East Anglia ONE North and East Anglia TWO Offshore Windfarms

Applicants' Responses to Examining Authority's Written Questions 2

Volume 8 – 2.18 Transportation and Traffic

Applicants: East Anglia ONE North Limited and East Anglia TWO Limited
Document Reference: ExA.WQ-2.D6.V1_08
SPR Reference: EA1N_EA2-DWF-ENV-REP-IBR-001239_08 Rev 01

TITLE
 SWEEP PATH ANALYSIS
 A1094/B1122 ROUNDABOUT

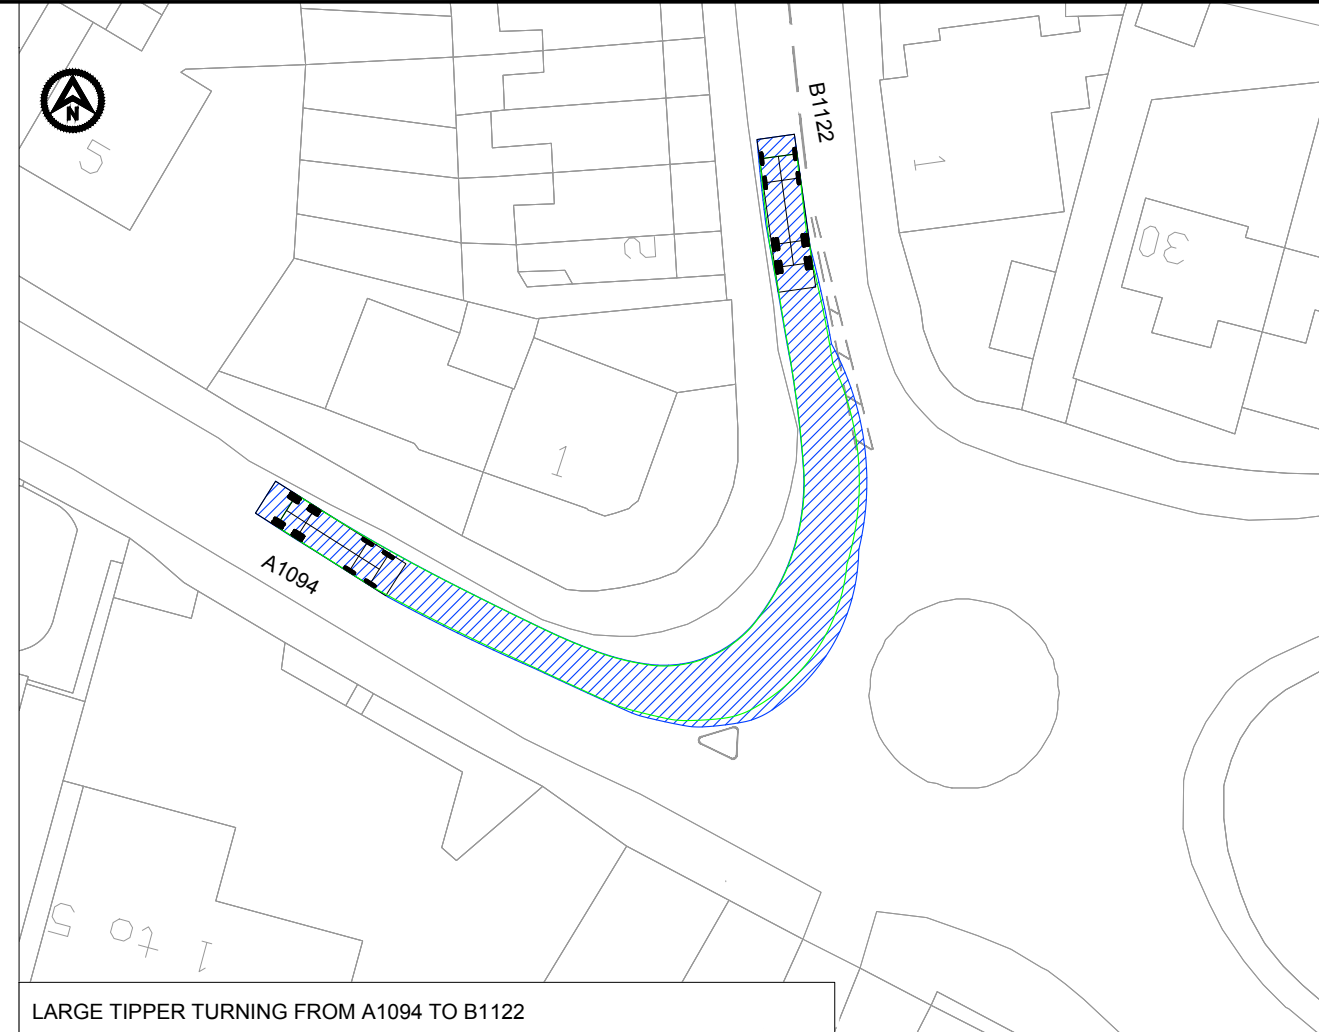
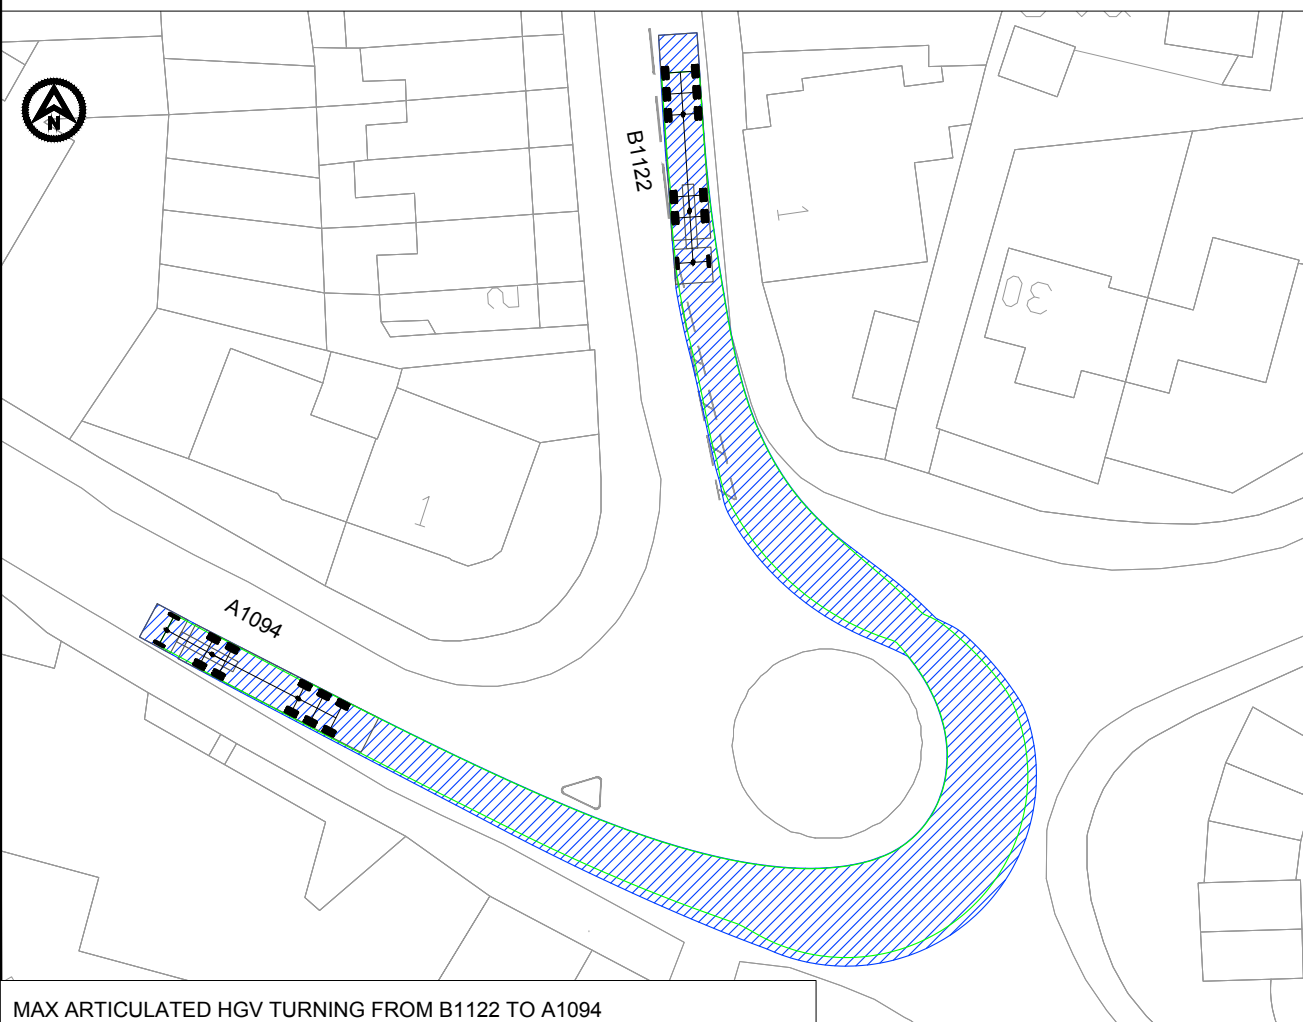
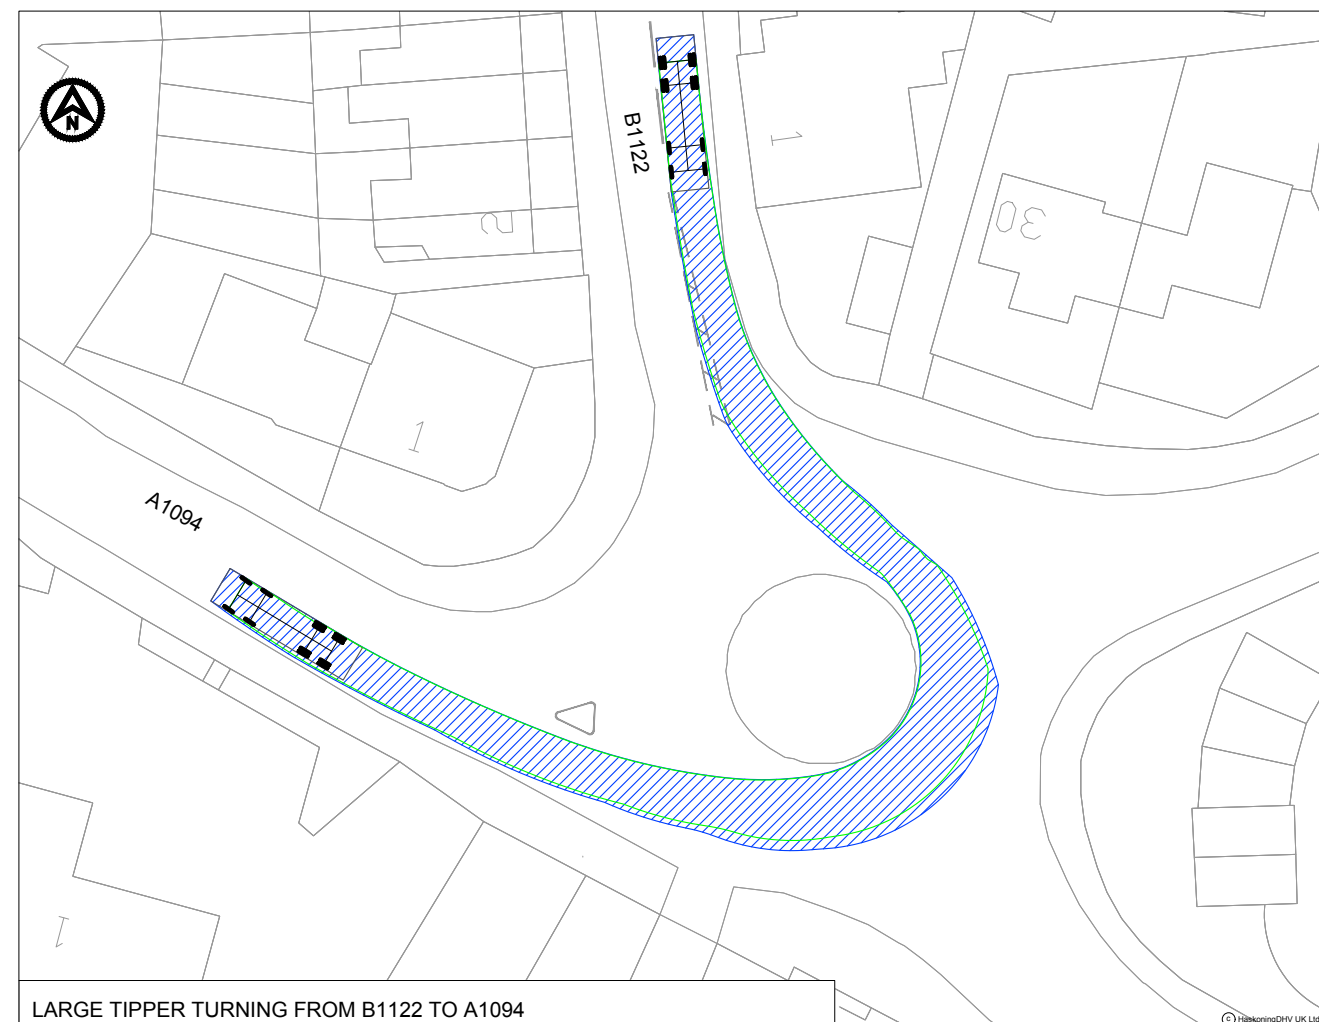
2.18.11	Applicants	<p>Local issues and effects – HGV traffic</p> <p>The junctions on the A1094 with the B1122 and the B1069 have been assessed by the Applicants as sensitive, and the Applicants have undertaken swept path analysis.</p> <p>In relation to this swept path analysis and diagrams (Appendix 26.21 Swept Path Analysis Sensitive Junctions [APP-547]), some information appears to be missing and in order to aid our understanding of the diagrams we asked about it in our ExQ1.18.50.</p> <p>The Applicants' response to our question 1.18.50 indicates that we were not clear so, to give more detail:</p> <ul style="list-style-type: none"> a) The top left-hand diagram on both the drawings in Appendix 26.21 Swept Path Analysis Sensitive Junctions [APP-547] appears not to show the entry vehicle; b) Please also add the entry vehicle to the bottom left hand diagram and the exit vehicle to both right hand diagrams on the second drawing; and c) please add arrows showing clearly the direction of travel of each vehicle on each diagram. 	<p>The Applicants welcome the ExA clarification and have amended the drawings as requested. A copy of the revised Appendix 26.21 (APP-547) drawings are provided within Appendix 1 of this response (document reference ExA.WQ-2.D6.V1_A1).</p>

ExA. Question Ref.	Question addressed to	ExA. Question	Applicants' Response
2.18.12	Applicants	<p>Local issues and effects – HGV traffic</p> <p>The junctions on the A1094 with the B1122 and the B1069 have been assessed by the Applicants as sensitive, and the Applicants have undertaken swept path analysis [APP-547].</p> <p>In respect of the A1094/B1122 junction at Aldeburgh, the Applicants' response to our ExQ1.18.51 states that this swept path analysis <i>“demonstrates that an articulated HGV would oversail into the opposite lane when turning from the A1094 onto the B1122. If this lane was blocked by an oncoming vehicle the HGV would not be able to make the manoeuvre. The HGV or oncoming driver, may therefore have to reverse which may not be possible with following traffic, leading to driver delay. A pilot vehicle would run ahead of the vehicle it is escorting. At the junction of the A1094 and B1122, the pilot vehicle would stop any oncoming traffic to allow the following HGV to pass any oncoming traffic.”</i></p> <p>We have visited this junction and observed its operation [EV-007c, EV-007d], noting in particular the presence of vehicles parked on both the A1094 and B1122 arms close to the roundabout junction. These are not shown on the swept path analysis, which appears to assume no obstructions on the highway.</p> <p>Given the presence of parked vehicles, is it still the Applicants' intention to route HGV and large tipper vehicles through the A1094/B1122 junction? If so:</p>	<p>a) and b) Appendix 26.21 has been revised to address the ExA clarifications provided at 2.18.12. This revised plan (provided in Appendix 1) also now includes the existing parking restrictions in advance of the roundabout on the A1094 and B1122. These include 'zig-zag' markings on the A1094 (associated with the zebra crossing) and double yellow lines around the roundabout and on the B1122. The swept path analysis presented in Appendix 1 is based upon no drivers parking illegally.</p> <p>With regards to the presence of oncoming vehicles, cyclists and pedestrians' drivers would follow the same rules as all other road users in giving way to oncoming traffic at the roundabout, or pedestrians and cyclists. Appendix 1 demonstrates that a large HGV tipper vehicle can make the manoeuvre within its own lane and would therefore not conflict with oncoming traffic. Appendix 1 further demonstrates that an articulated HGV could sweep slightly out into the oncoming lane when turning from the A1094 to B1122. The use of a pilot vehicle is therefore proposed to manage this potential conflict.</p> <p>c) The use of a pilot vehicle is common practice for escorting loads throughout the UK, for example, mobile homes and large farm machinery. The Traffic Signs Manual Chapter 8 (2009), published by the Department for Transport outlines that an operative can stop traffic for up to two minutes through the use of the 'Stop-Works' sign.</p>

ExA. Question Ref.	Question addressed to	ExA. Question	Applicants' Response
		<p>a) please demonstrate whether and if so how both an HGV and a large tipper can safely negotiate this junction in the presence of parked vehicles, oncoming traffic, and other road users such as cyclists and pedestrians;</p> <p>b) Given that the lane is already partially blocked by parked vehicles, please explain in more detail how the presence of a pilot vehicle would safely assist; and</p> <p>c) Would the driver of the pilot vehicle have the necessary legal powers to stop traffic?</p>

SWEPT PATH ANALYSIS
 A1094 / B1069 JUNCTION

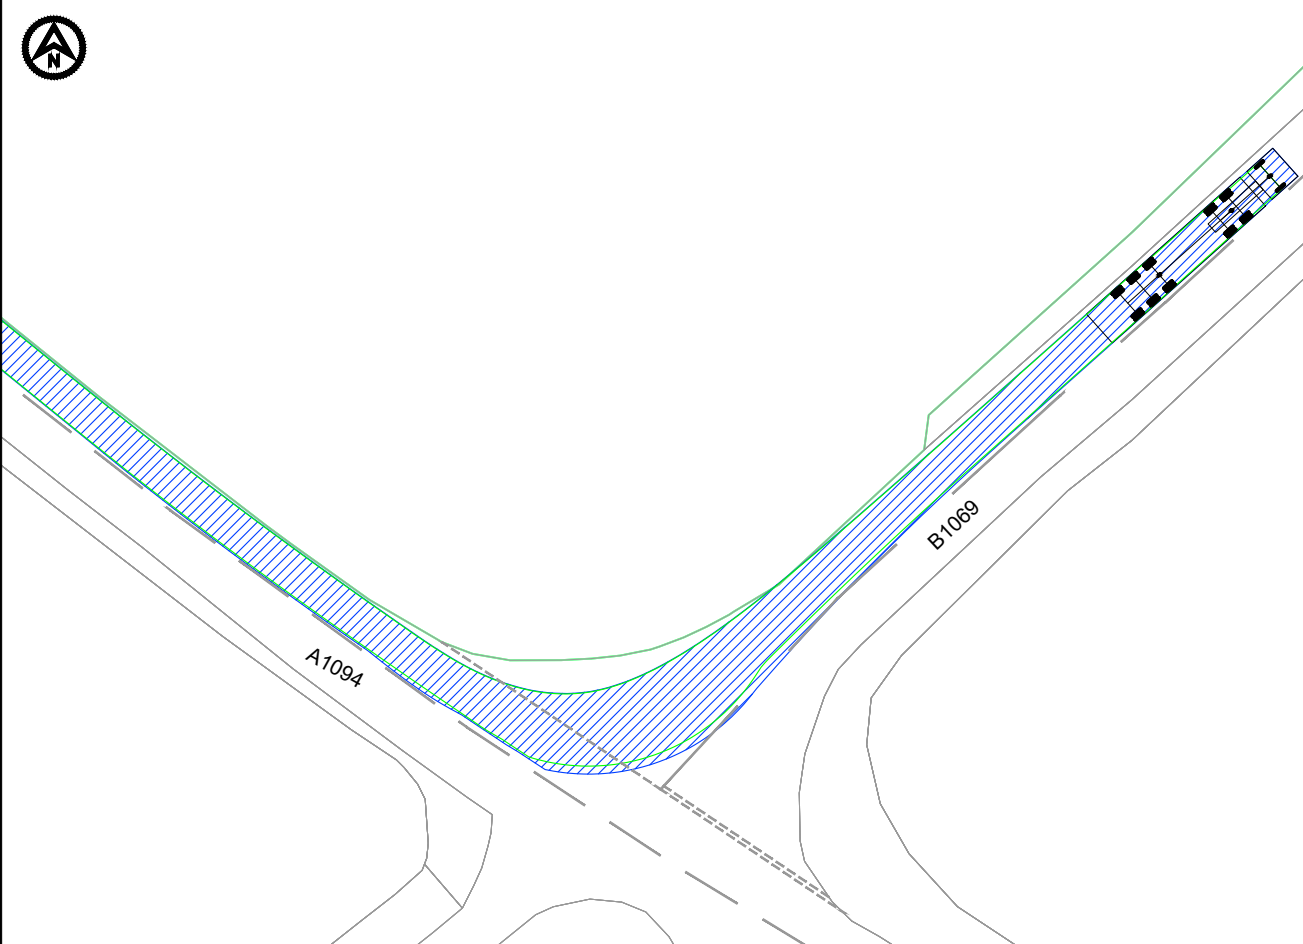
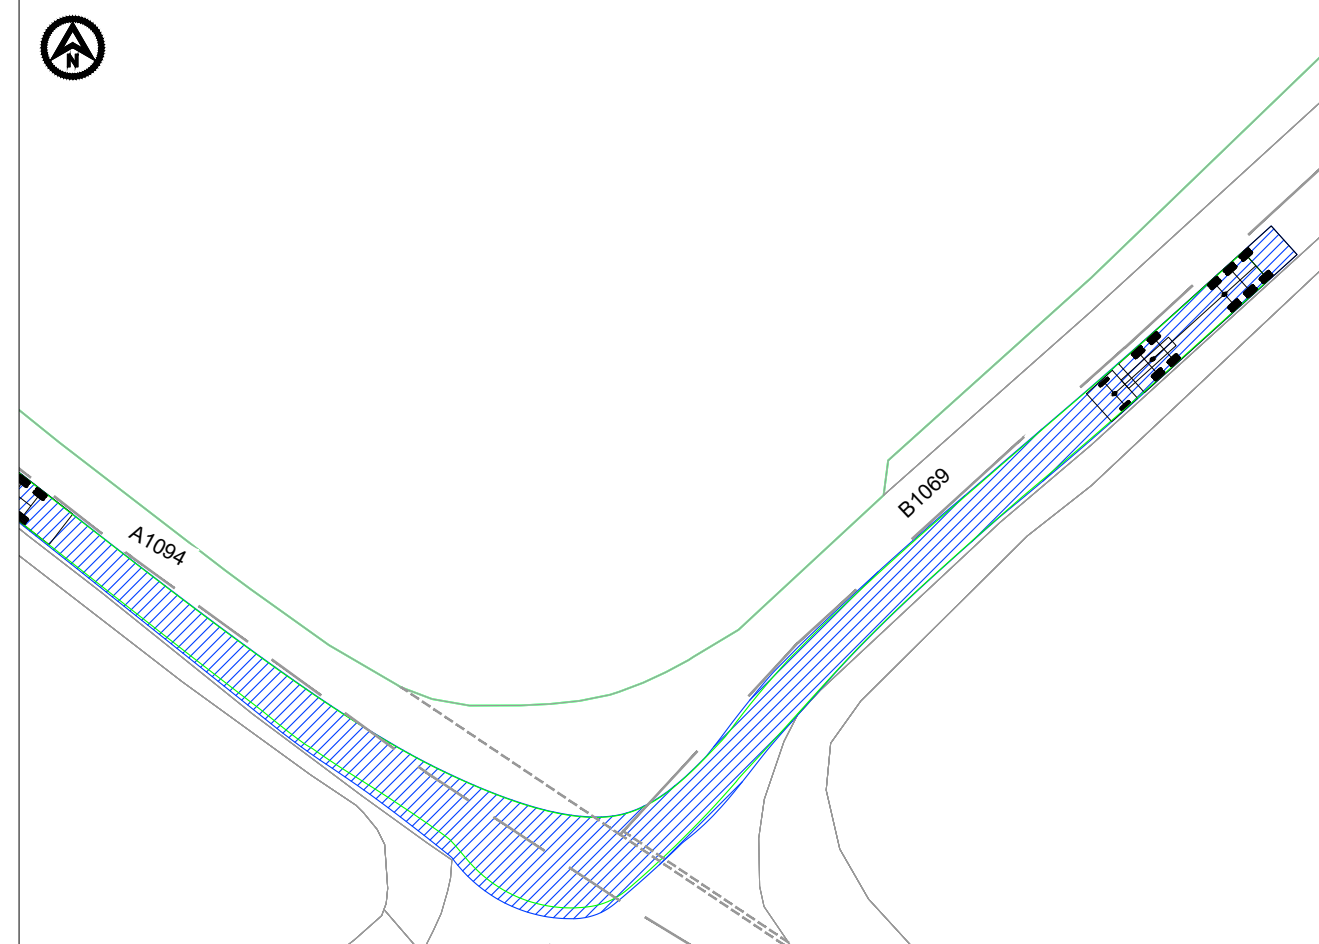
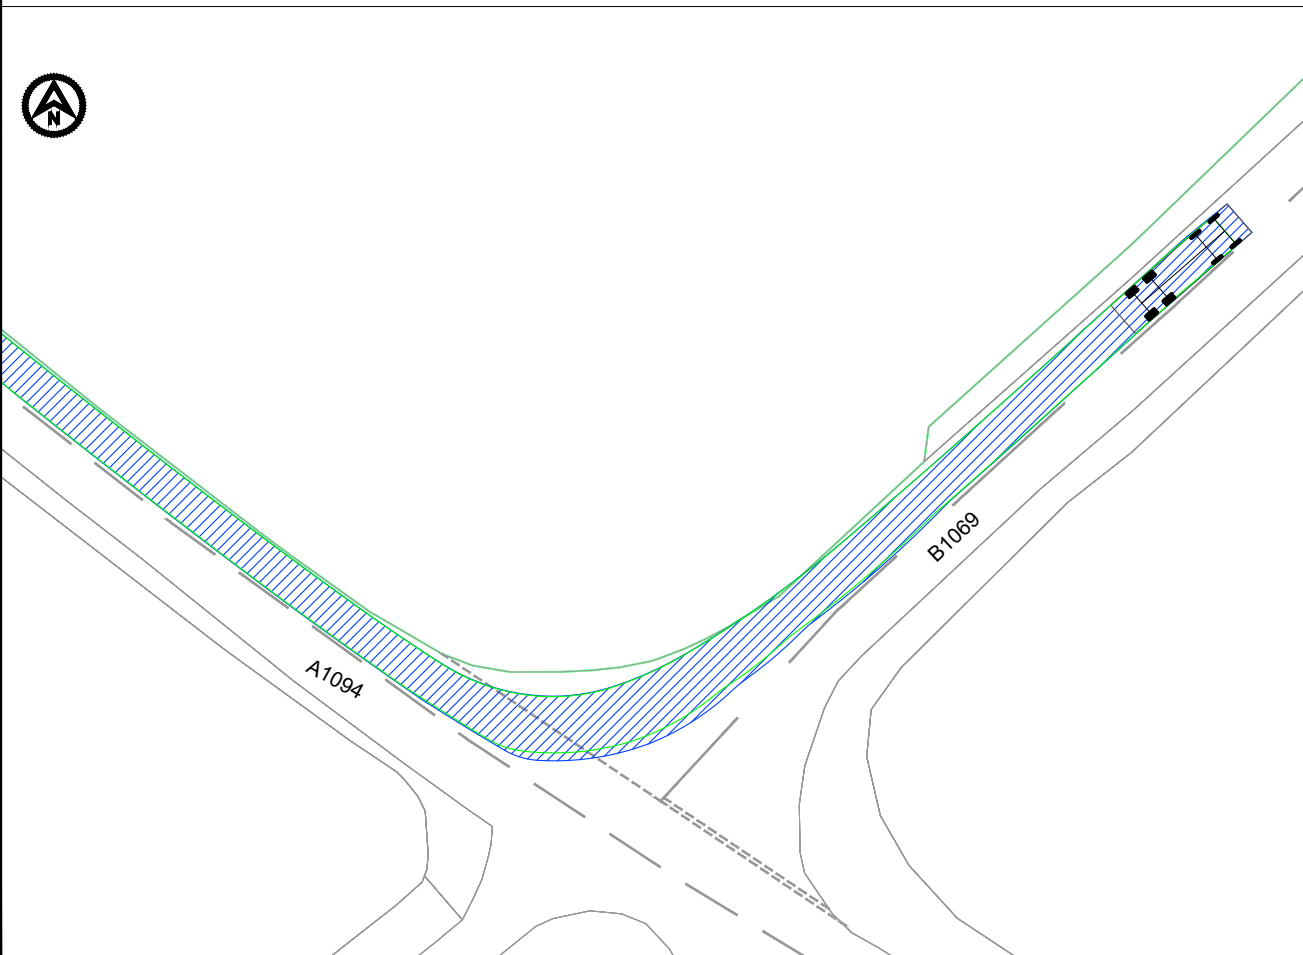
2.18.13	Applicants	<p>Local issues and effects – HGV traffic</p> <p>The junctions on the A1094 with the B1122 and the B1069 have been assessed by the Applicants as sensitive, and the Applicants have undertaken swept path analysis [APP-547].</p> <p>In respect of the A1094/B1069 junction, we note that the swept path diagrams show that HGV oversail on both manoeuvres and that the tipper oversails making the right turn out of the B1069 onto the A1094.</p> <p>We have visited this junction and observed its operation [EV-007a], noting in particular the poor visibility in both directions on the A1094, particularly for vehicles turning right from the B1069 onto the A1094.</p> <p>In view of this:</p> <p>a) would a pilot vehicle also be used at the B1069 junction?</p>	<p>Appendix 26.21 (APP-547) identifies that a vehicle can turn from the A1094 to the B1069 without oversailing into the oncoming lane. There is a small area of over sail associated with vehicles turning from the B1069 to the A1094, this area is however hatched out to accommodate these types of existing manoeuvres. Appendix 26.21 has been revised to highlight this area of hatching and a copy of the revised drawing is provided within Appendix 1 of this note.</p> <p>a) noting the clarification provided above there would be no requirement to provide a pilot vehicle;</p> <p>b) no pilot vehicle is proposed; and</p> <p>c) no measures are proposed at this junction as the swept path analysis provided within Appendix 1 indicates that the junction can be negotiated by HGVs. Furthermore, a review of the existing road safety baseline at the junction presented within the Chapter 26 (APP-074) has not identified any existing road safety issues that would be exacerbated by the Projects' traffic.</p>

ExA. Question Ref.	Question addressed to	ExA. Question	Applicants' Response
		<p>b) If so, would the driver of the pilot vehicle have the necessary legal powers to stop traffic? and</p> <p>c) if not, what measures are proposed to safeguard other road users at this junction?</p>
